Emailed August 8, 2023
DHO Comments for Meeting on 8/23/2023

RE: DHO COMMENTS for PR-2022-006568

LOTS 4 AND 5, BLOCK 16 TRACT 3, NORTH ALBUQUERQUE ACRES: ZAP: C-20
SD-2023-00147 PRELIMINARY PLAT • No adverse comments to the preliminary plat

PR-2022-006568 / SD-2023-00147 (9200 Wilshire Ave NE)

PRELIMINARY PLAT
 VALENTINO ESTATES
 (A REPLAT OF LOTS 4 & 5,
 BLOCK 16, TRACT 3, UNIT 3,
 NORTH ALBUQUERQUE ACRES)
 WITHIN THE
 ELENA GALLEGOS GRANT
 PROJECTED SECTION 17
 TOWNSHIP 11 NORTH, RANGE 4 EAST, N.M.P.M.
 CITY OF ALBUQUERQUE,
 BERNALILLO COUNTY, NEW MEXICO
 JUNE, 2023

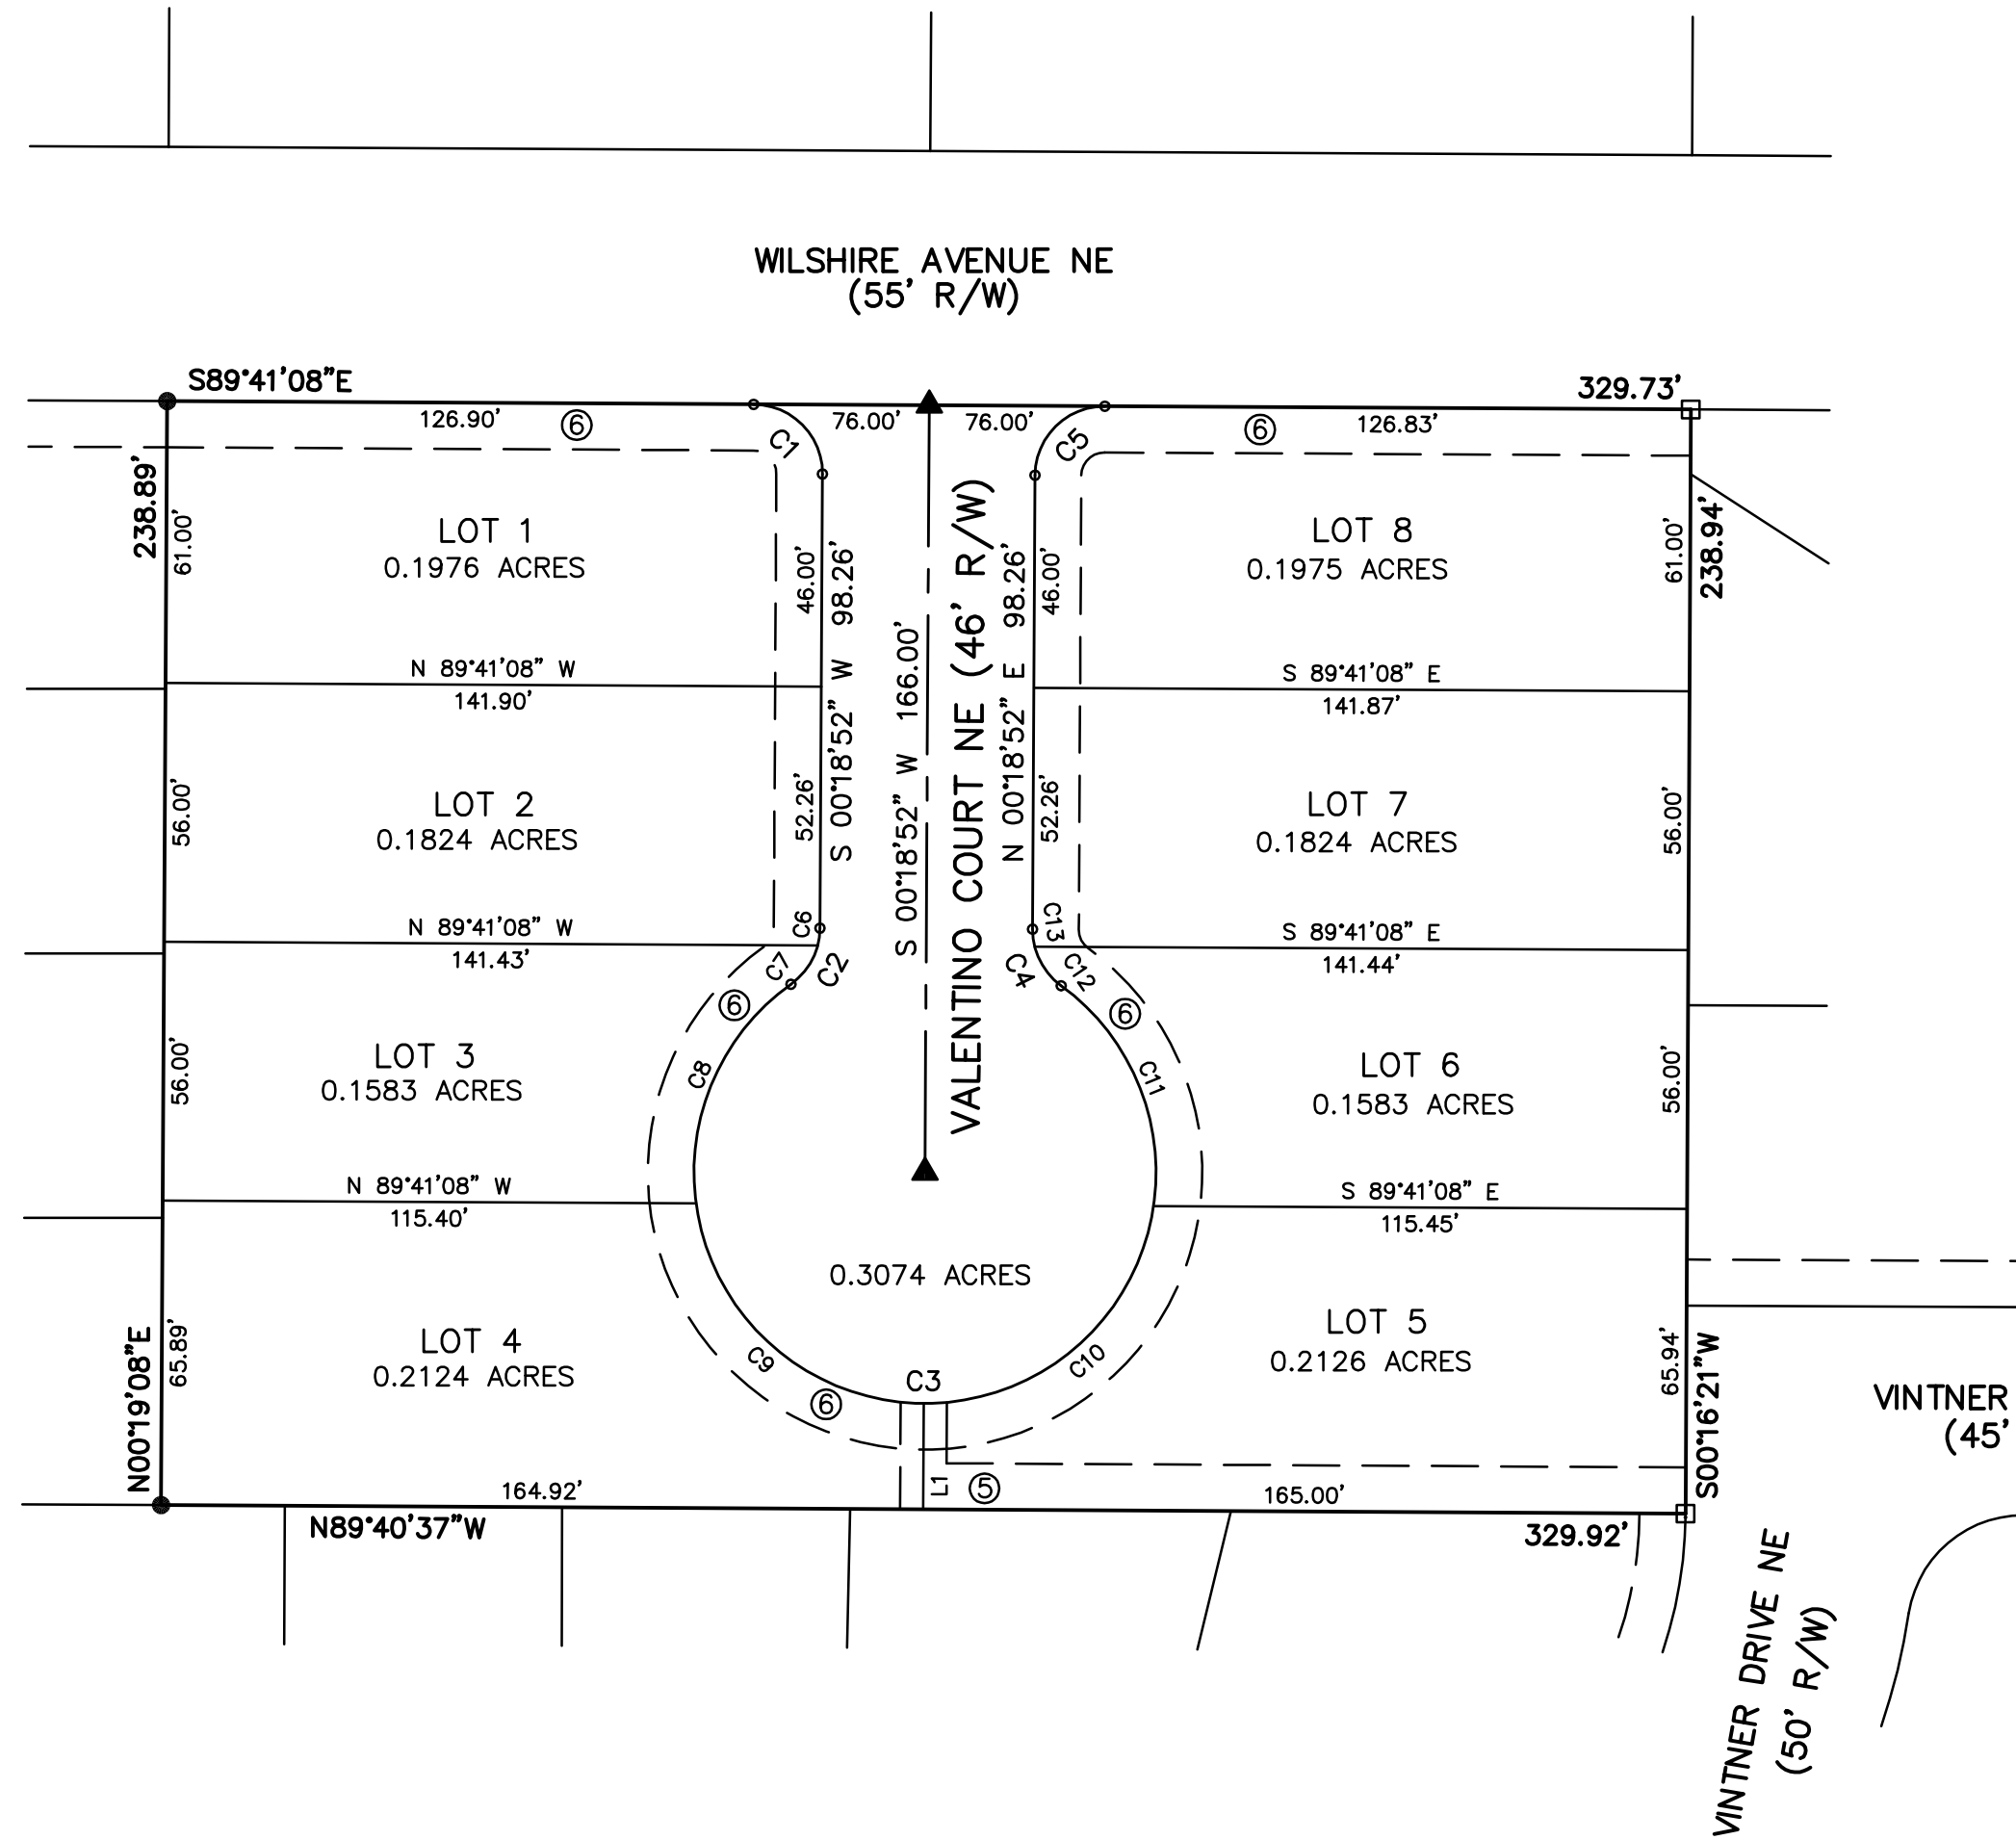
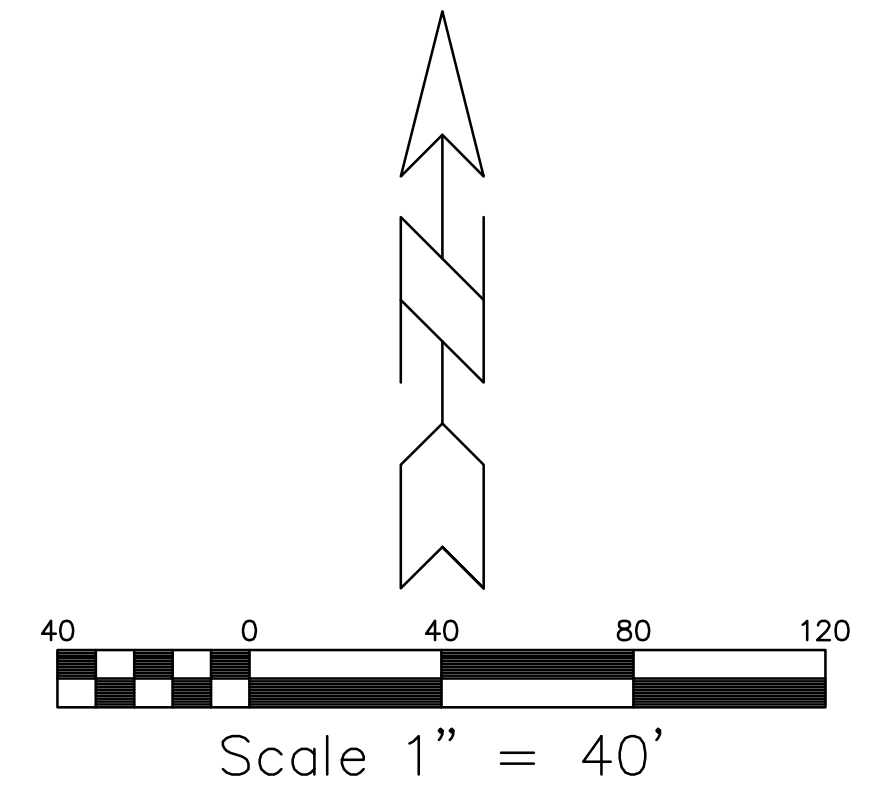
2. Any existing and/or new PNM easements and facilities need to be reflected on the resulting Plat.
3. There are existing PNM facilities and/or easements located near the southeast corner of the site.

4. Any existing easements may have to be revisited and new easements will need to be created for any electric facilities in the alley proposed to be vacated as determined by PNM.
